WELWYN HATFIELD BOROUGH COUNCIL – DEVELOPMENT MANAGEMENT
DELEGATED REPORT

APPLICATION No:	S6/2012/2424/FP
APPLICATION Site:	Anchor Cottage, Vineyards Road

The proposal seeks planning permission for a part single storey, part two storey rear extension creating an extended kitchen/diner on the ground floor and a third bedroom on the first floor.

GROUND FLOOR PLAN 1:50

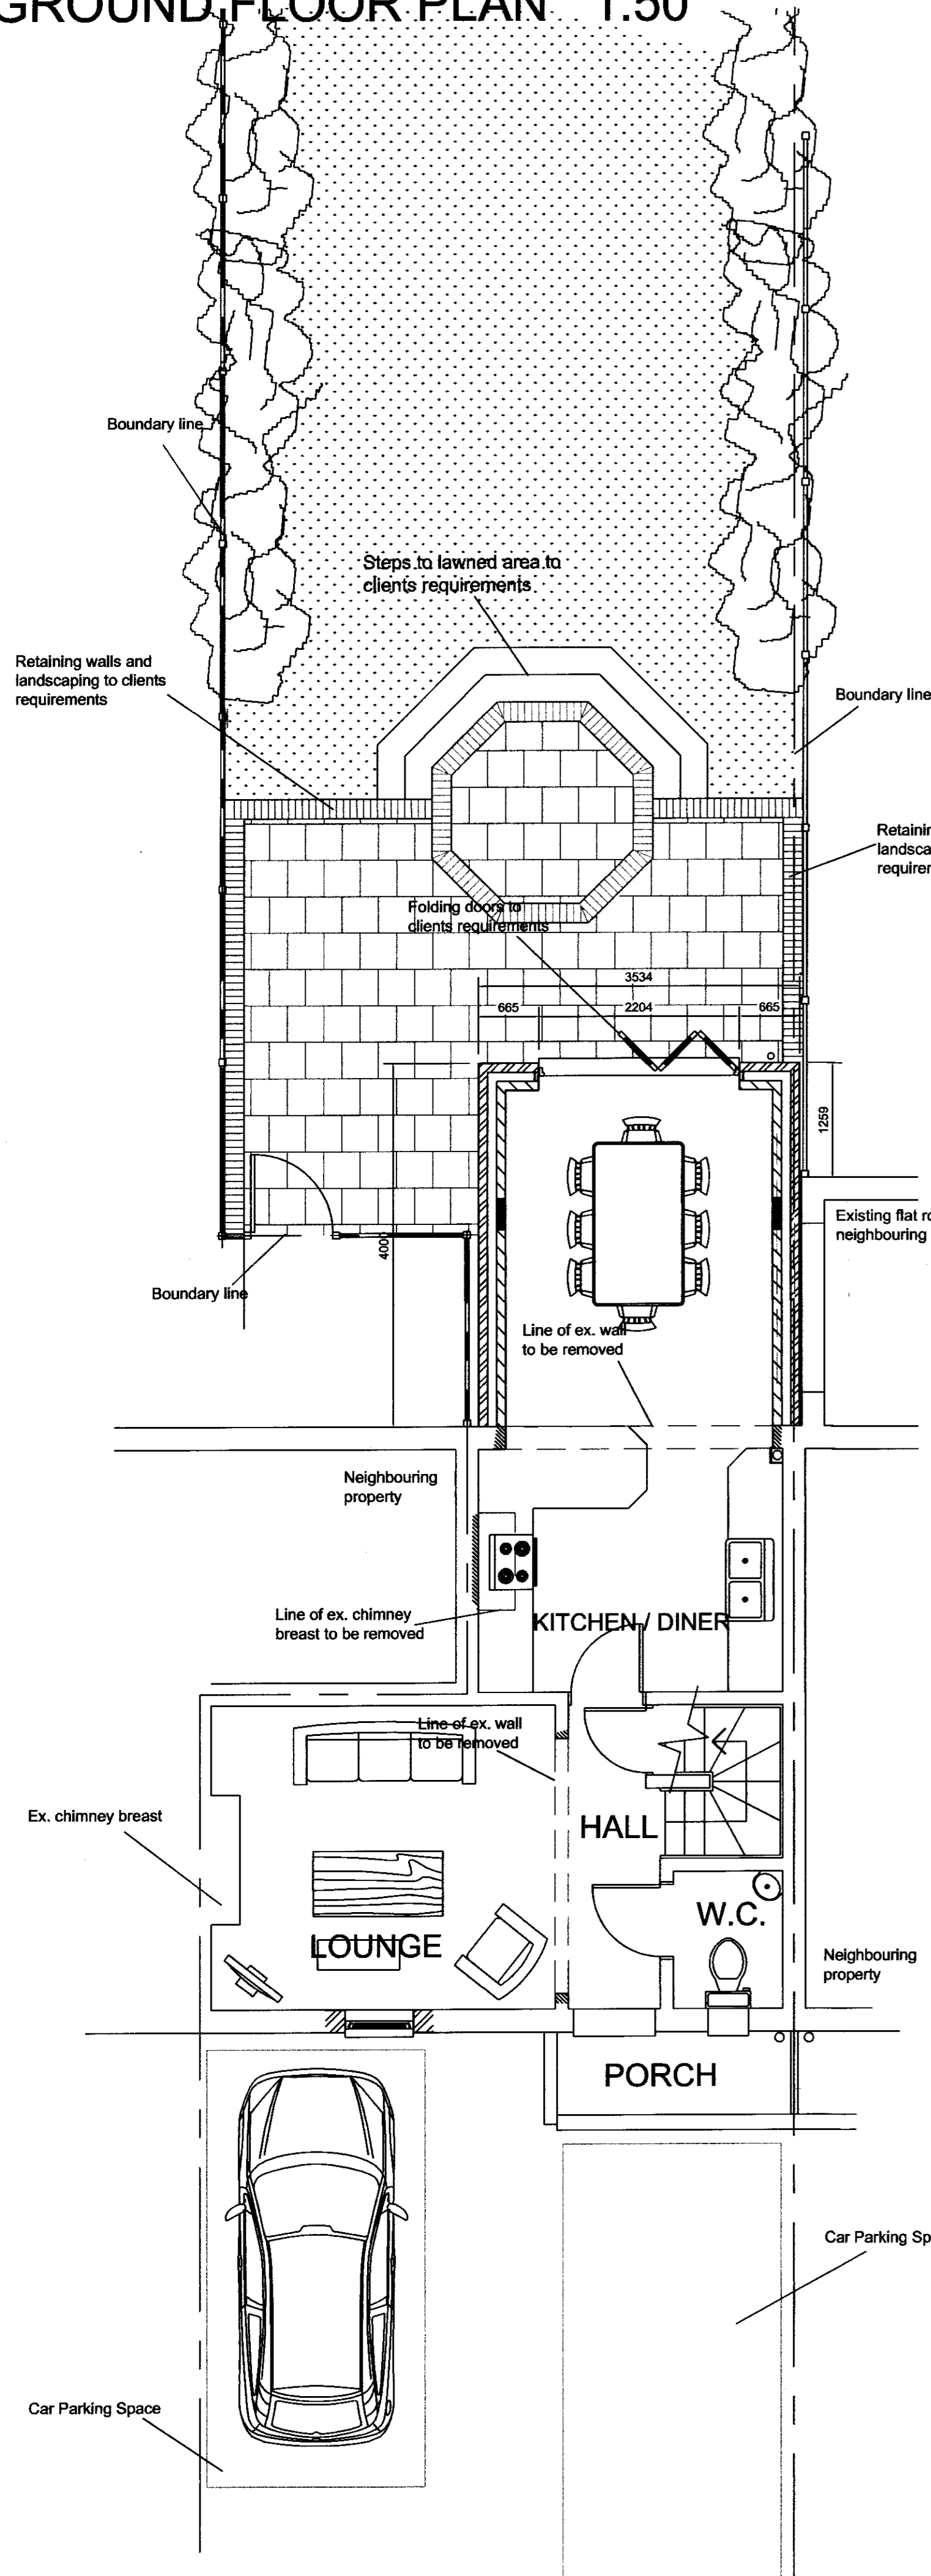
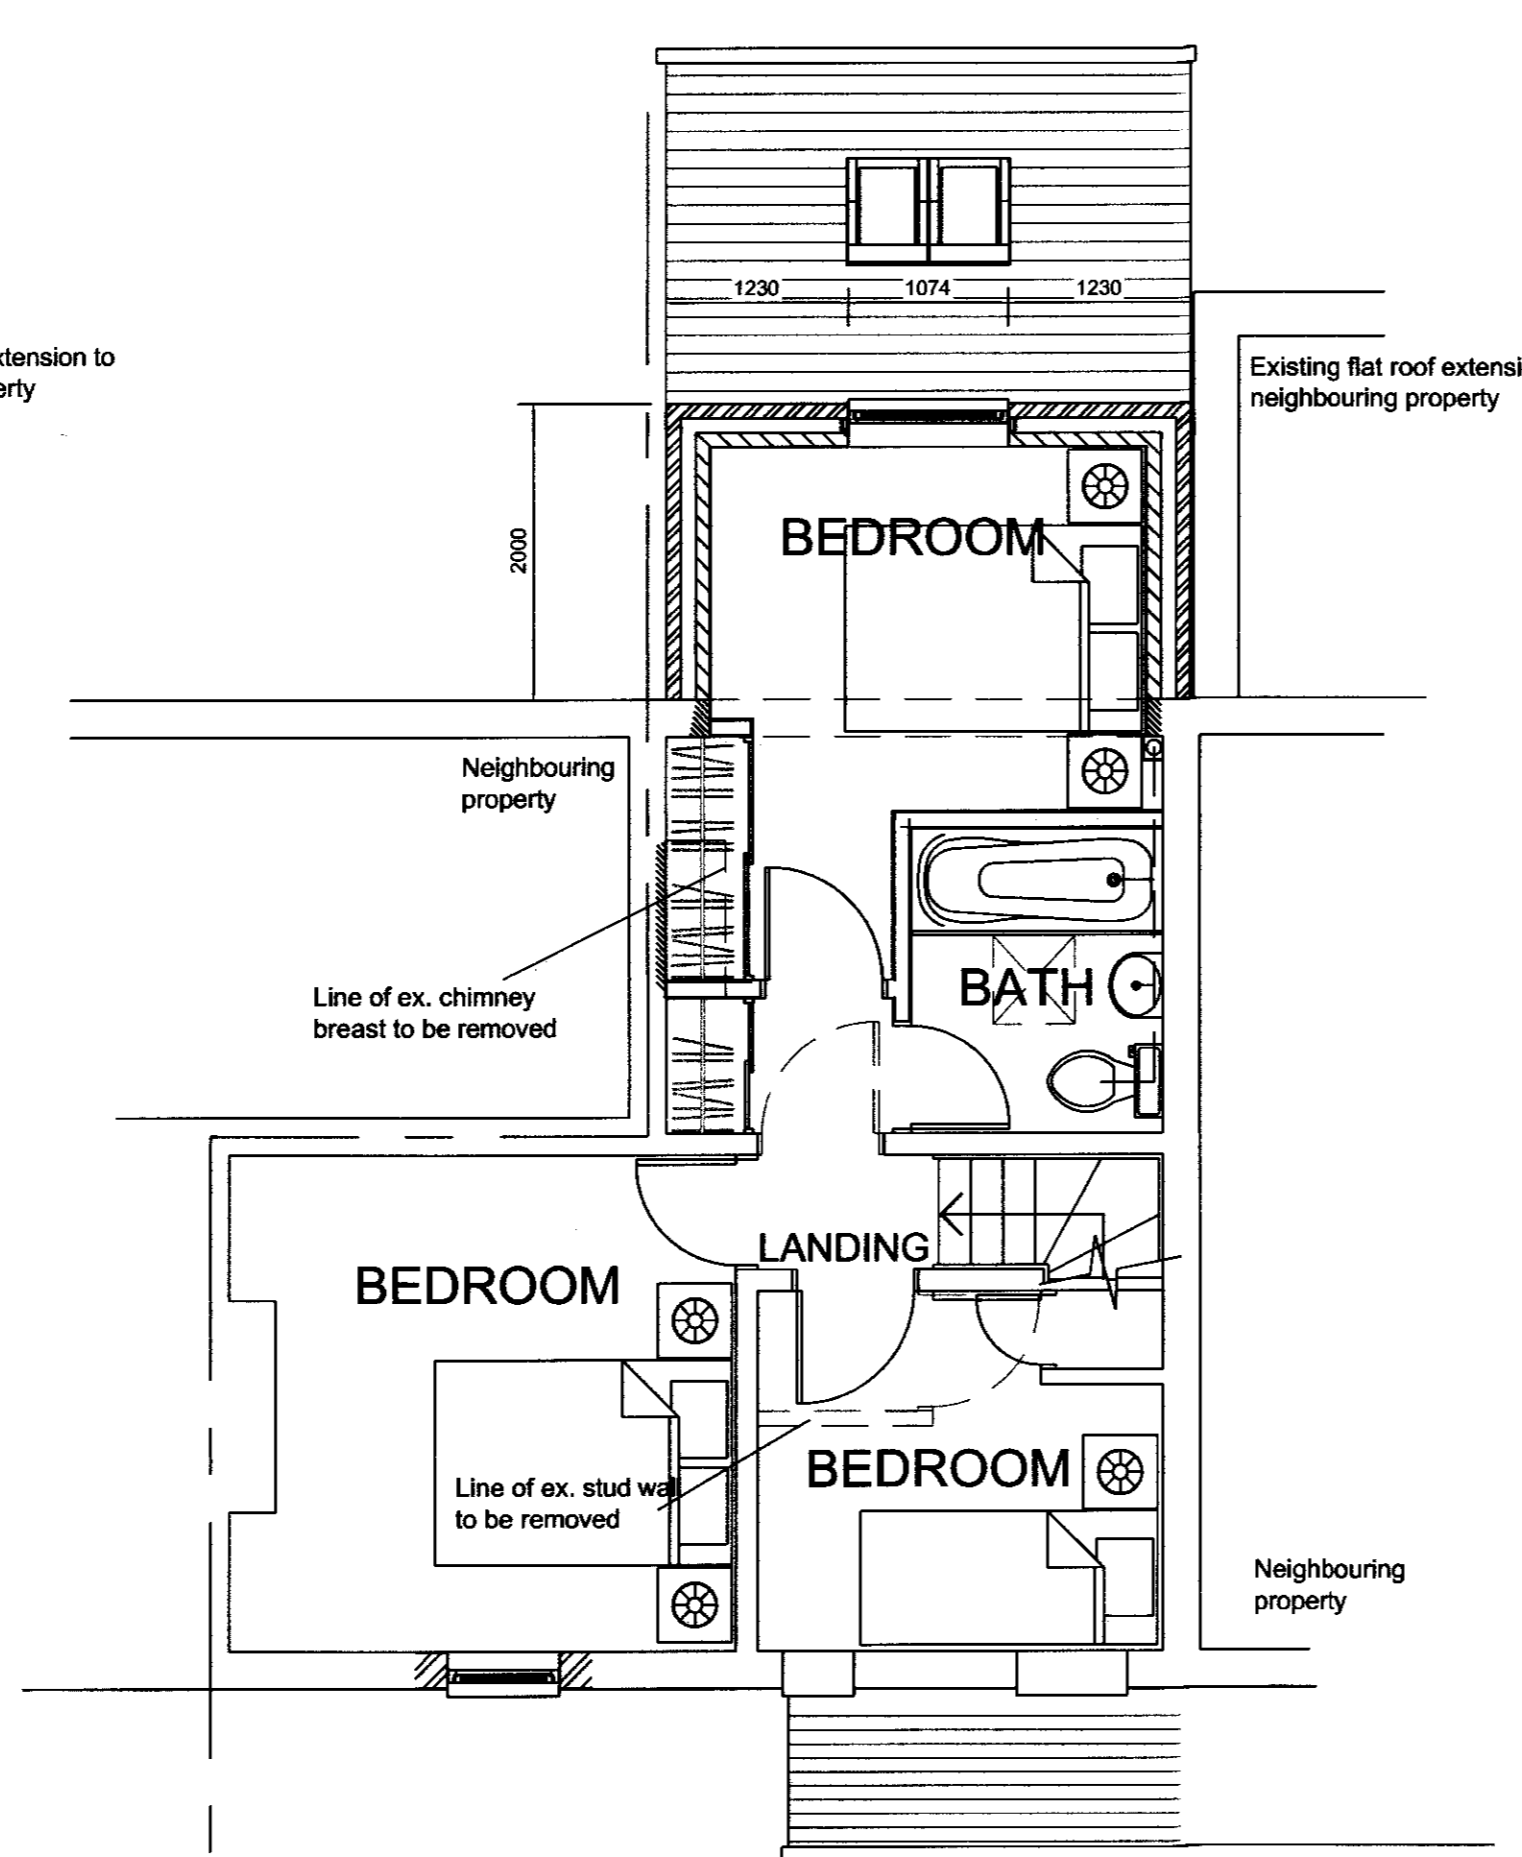
Floorspace	Footprint
Original Dwelling		
Ground Floor	34sqm	
First Floor	34sqm	
Total	68sqm	34sqm

Proposed Floorspace		
Ground Floor	14sqm	
First Floor	7sqm	
Total	21sqm	14sqm
	31% increase	41% increase

The proposed extensions would add a further 31% increase upon the original dwellinghouse and a footprint of 41% which is not considered disproportionate.

PROPOSED ELEVATIONS 1:100

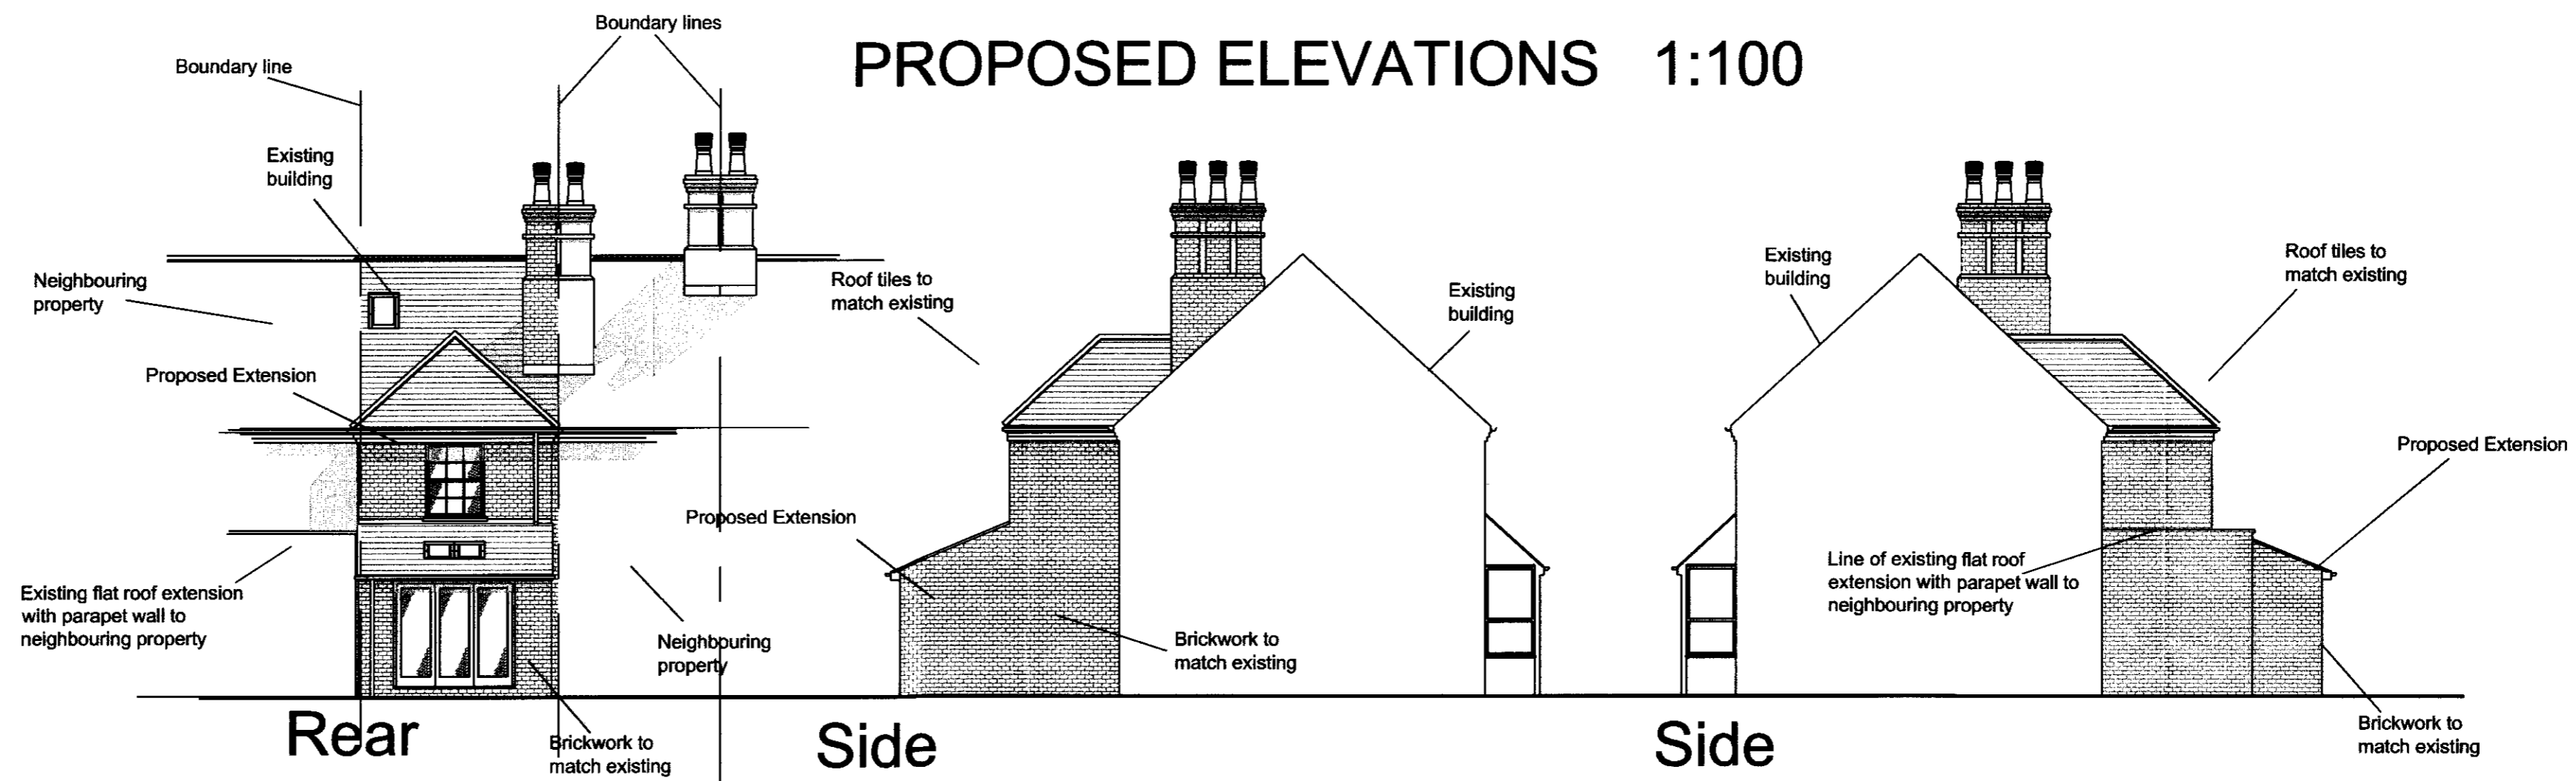
Turning to the overall visual impact of the proposal on the openness of the Green Belt, this is particularly important, as floorspace assessments in isolation may not suffice, as irrespective of the floorspace increase Policy RA3 also looks at the overall resultant size and its visual impact on the countryside. In regards to the overall visual analysis of the proposal and taking into account the increase in floor areas mentioned above, it is considered that the additions would not have an adverse visual impact on the character of the surrounding countryside as they appear proportional when compared to the original dwelling, are located to the rear of the dwelling and the roofspace above the two storey extension has been hipped to match the pitch of the existing dwellinghouse.

Furthermore, the materials to be used in the construction of the proposed extension and the window fenestration have been designed to match the existing dwellinghouse.

The dwellings most impacted by the proposal are neighbouring properties, Hope Cottage to the north east and Nyn Manor Farm to the south west. A single storey rear extension exists at Hope cottage measuring approximately 2.7m in depth. The proposed single storey extension will extend a further 1.3m in depth beyond this extension which is not considered to result in a detrimental impact upon Hope Cottage in terms of loss of sunlight/daylight. With regards to the proposed first floor

extension, a first floor window is located on the rear elevation of Hope Cottage which forms a bedroom. Due to the orientation of Hope Cottage in relation to the proposed extension, the existing first floor rear window will result in some loss of light late afternoon however, this level of loss is not considered to be detrimental to warrant refusal. Furthermore, the 2m depth extension at first floor level will not result in an overbearing impact taking into consideration the distance of the midpoint of neighbouring first floor window of approximately 1.7m in relation to the proposed first floor rear extension and the proposed hipped roof design.

A ground and first floor window exist on the rear elevation of Nyn Manor Farm Cottage, the midpoint of both windows measure approximately 1.7m from the flank wall of the proposed two storey extension. The orientation of the rear gardens are to the North West and therefore the proposed two storey rear extension in relation to the Nyn Manor Farm will not result in a detrimental loss of sunlight to warrant refusal.

Nyn Manor Farm Cottage is an end of terrace property set within a larger plot with a rear and side garden when compared to the application dwelling which is mid terraced. Naturally, both windows to the rear of Nyn Manor Farm Cottage would result in a reduction of daylight/skylight specifically the ground floor window which forms part of the kitchen. However, this loss of daylight/skylight is not considered to be detrimental to warrant due to the distance of approximately 1.7m between the two windows and the flank wall of the proposal.

Furthermore, with regards to outlook, the proximity of the proposal will result in some loss of outlook to the north from the existing ground and first floor window of Nyn Manor Farm however, the impact upon outlook from these two windows is not considered to be detrimental by virtue of both the distance of approximately 1.7m between the windows and the flank wall of the proposal and the fact that the dwelling has a more open outlook which extends both to the rear and side of the dwelling and therefore the natural outlook from these windows is not just to the rear when compared to the neighbouring application dwelling.
